16 June 2022

Plans for the site to the rear of 28 Northorpe Lane, Northorpe have once again undergone further changes in an attempt to make them acceptable to the Council Planning Officers. Nonetheless, I have to highlight further issues with the plans as they still stand, which if not addressed should result in a refusal of planning permission.

Drawing **Proposed Site Layout**

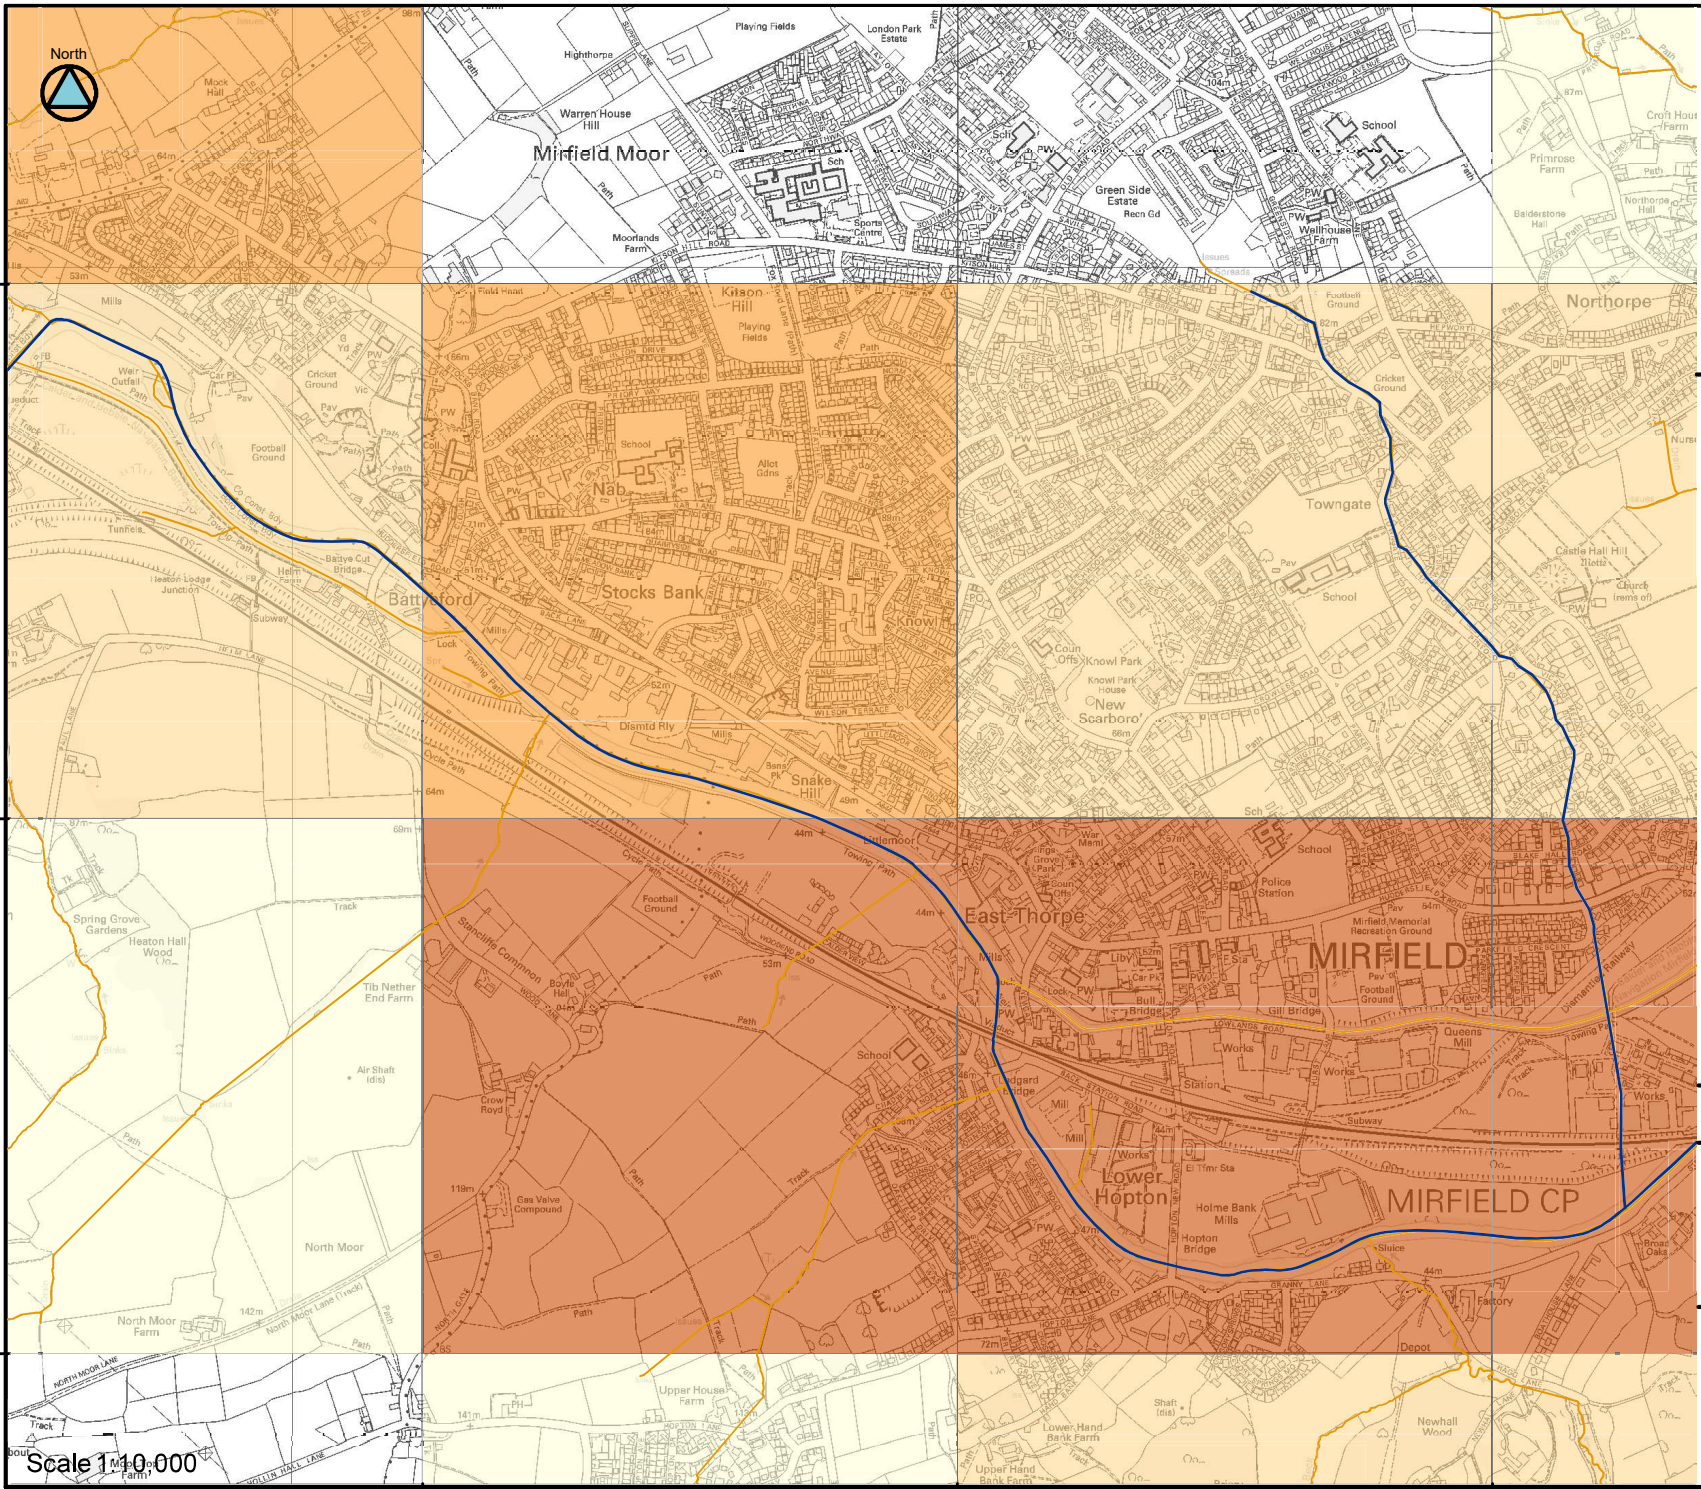
with a particular issue being the overbearing and inadequate separation between plot 11 and the existing property at 3 Northorpe Court.

Plot 11 is positioned uphill of and will look directly down into the existing property at 3 Northorpe Court in an overbearing and intrusive fashion. This design aspect in no way enhances the existing environment or is complementary to the amenity of Northorpe Village.

I therefore apply the similar stipulation that was used between plots 18 and 20 against a blow up of the Mulberry house design at plot 11 from reference 1 above, showing the separation to 3 Northorpe Court labelled as 22639 mm (= 22.6 metres). I have to make it clear that this 22.6 metre depiction in figure 1 is a mistake/misrepresentation by the architects since their labelled line is quite clearly not measured between the nearest habitable room windows. The correct datum of 3 Northorpe Court to measure the nearest habitable room window lies to the right (i.e. south) of the measurement on the latest site plan block layout drawing, and is now indicated in red on Figure 2 included below. When this nearer habitable window of 3 Northorpe Court is taken into account, the separation distance between habitable windows to plot 11 is quite clearly less than 21 metres. I have taken the measurements myself but the site architects will clearly see their error once you inform them of it.

Correct minimum separation of at least 21 metres to be achieved **between habitable windows** across the red line highlighted. Therefore plot 11 either has to be removed or resited much further to the north.

3. Dangerous and non compliant road radius on a blind bend adjacent to plot 28.
- Once again Latest site plan block layout refers
https://www.kirklees.gov.uk/beta/planning-applications/search-for-planning-applications/downloaddocument.aspx?application_number=2021%2f91914&file_reference=934061&size=2451614 , see Figure 3

Until there is a wholesale redesign of this blind bend marked with the red cross, this design is unsafe and it would be a mistake to allow it to continue. Great efforts have been made by the architects to achieve safe visibility arcs in response to previous feedback (see the green tick bends) BUT it would be a dereliction of obligation not to address the glaring danger to safety indicated by the red cross. The current approach is obviously inconsistent; two open bends with good visibility but one dangerous blind bend is not acceptable. Who would want to encounter the refuse lorry or Yorkshire Water Pumping station lorry coming around a blind bend with no warning?
